Address: 130 Vannah Ave

Permit # 2014-02138

CHECK-LIST AGAINST ZONING ORDINANCE

Proposed Use/Work - add 2nd floor to existing building

FRONT ELEVATION

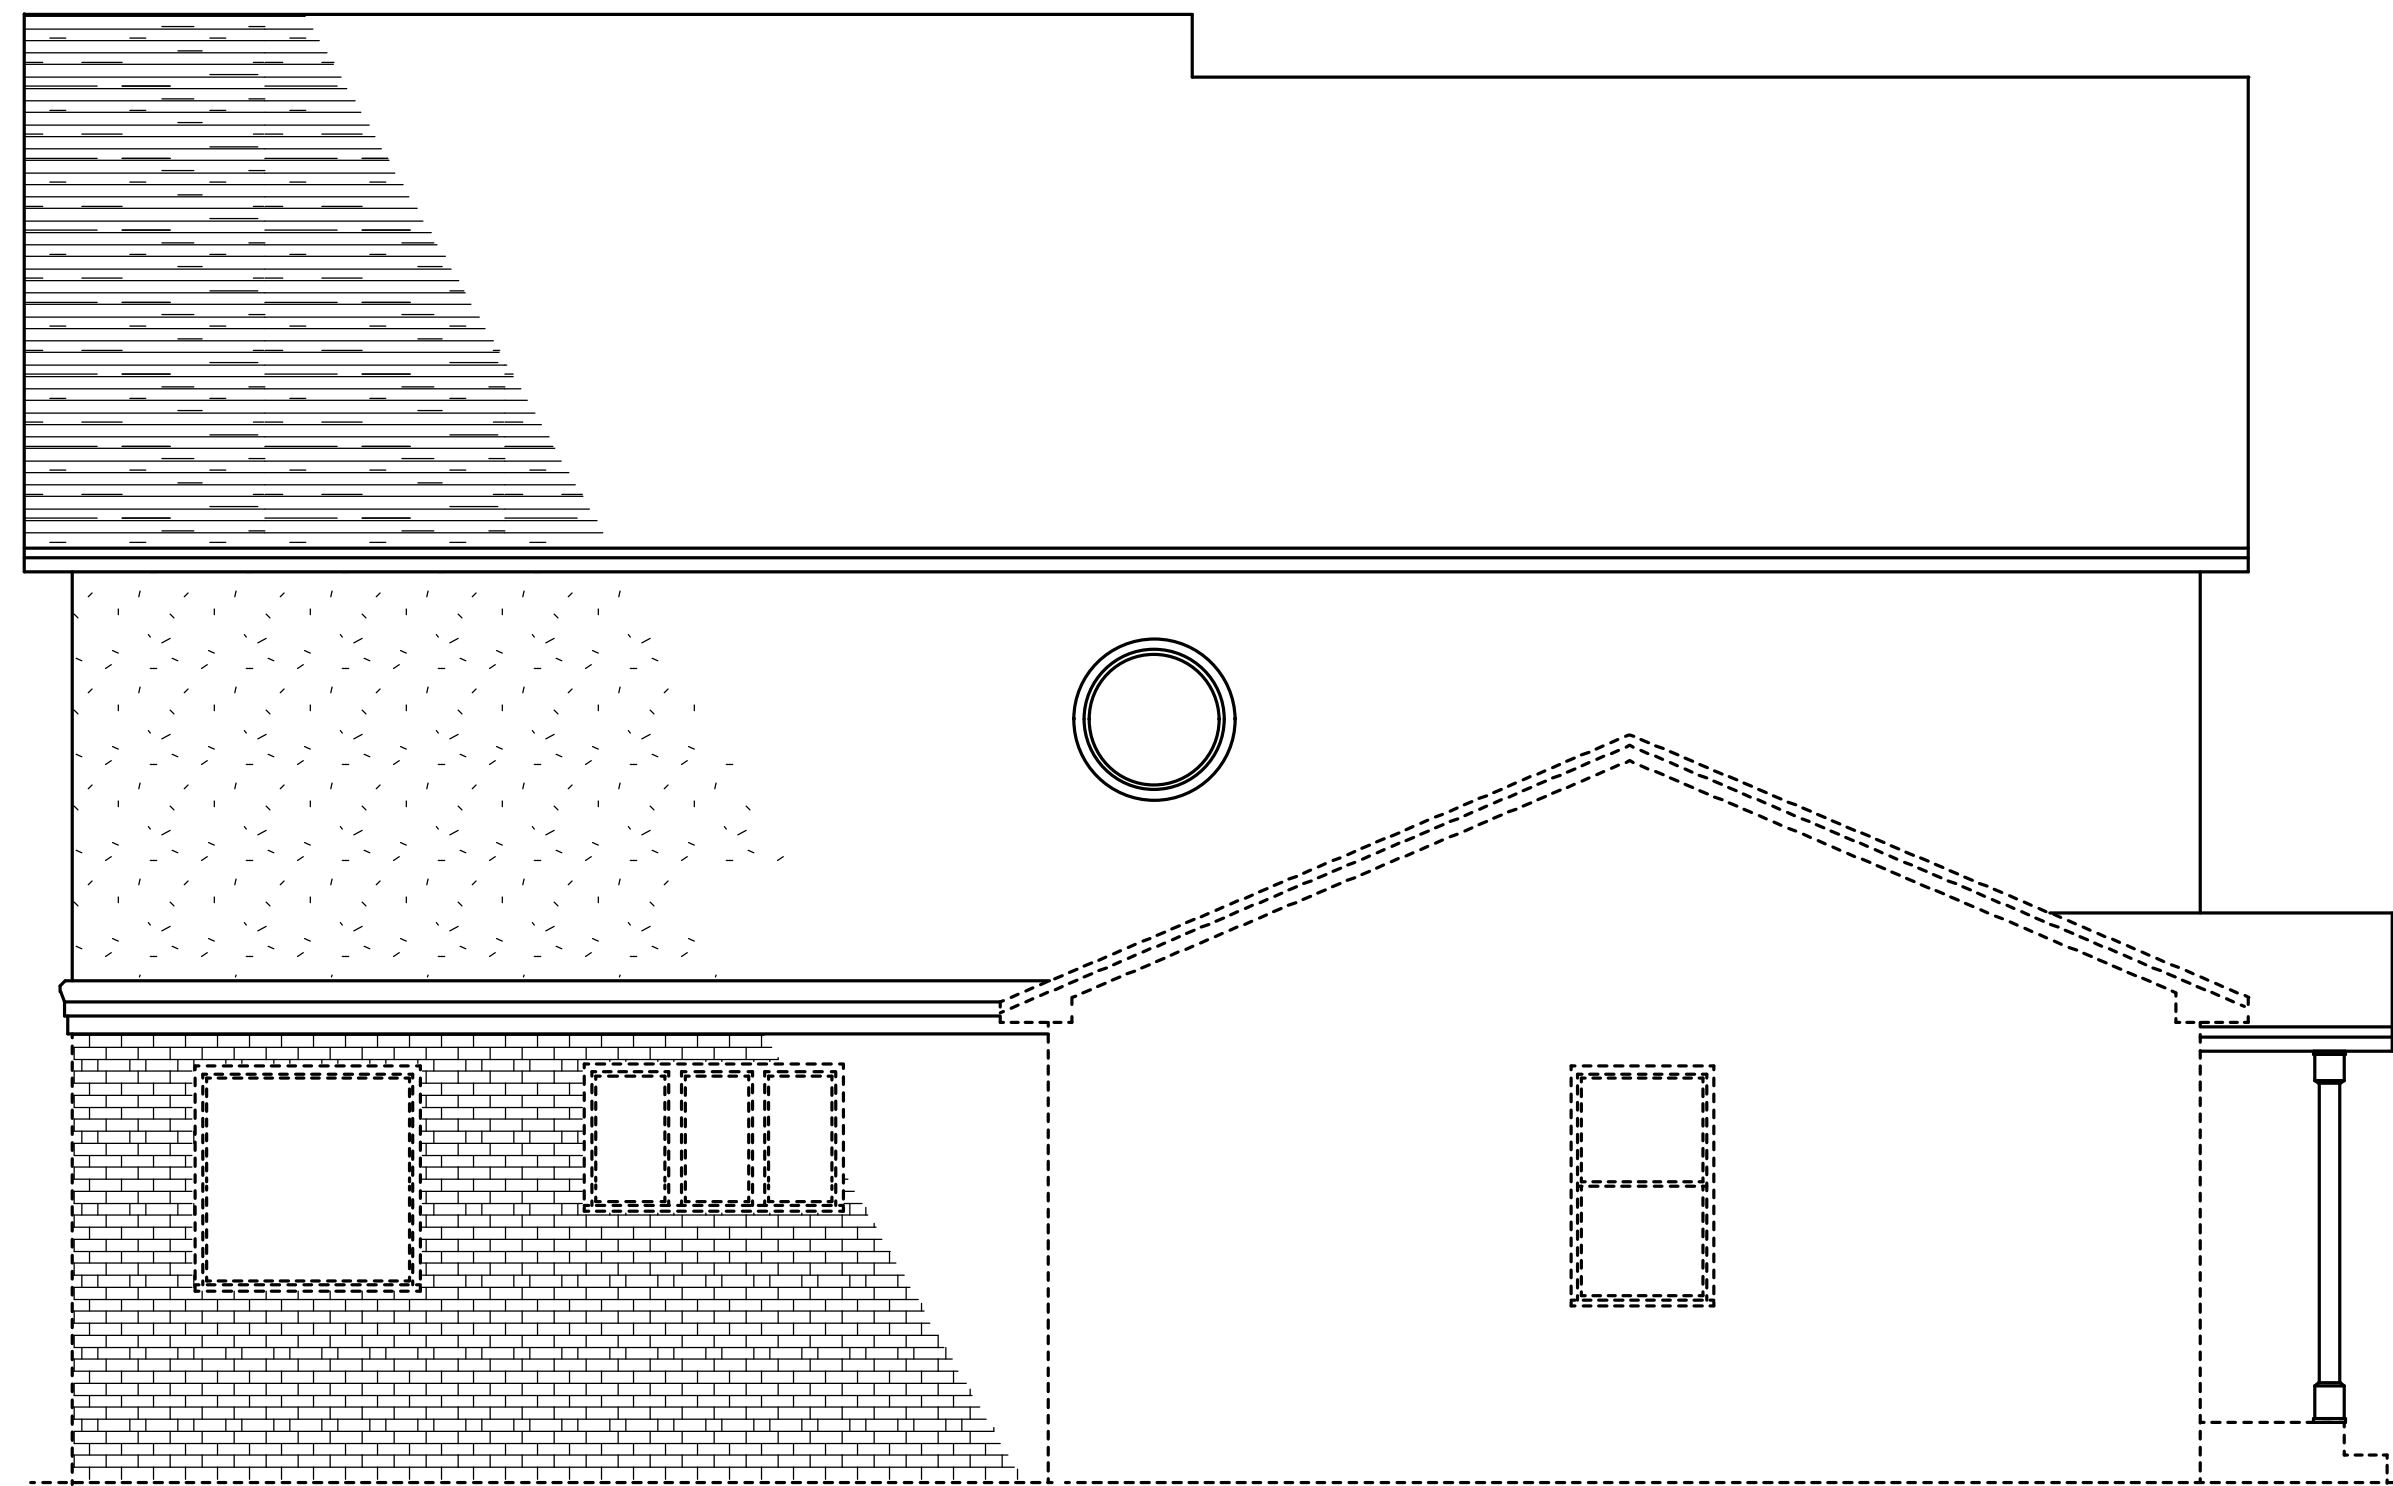
* Front Yard - 25' or average - no floor by 20' shown

* using section 14-436(b)

1st floor footprint - 2000 sq ft

2nd floor addition - 1544 sq ft

$$\frac{1544}{2000} = 77.2\%$$

allowed 80% (OK)
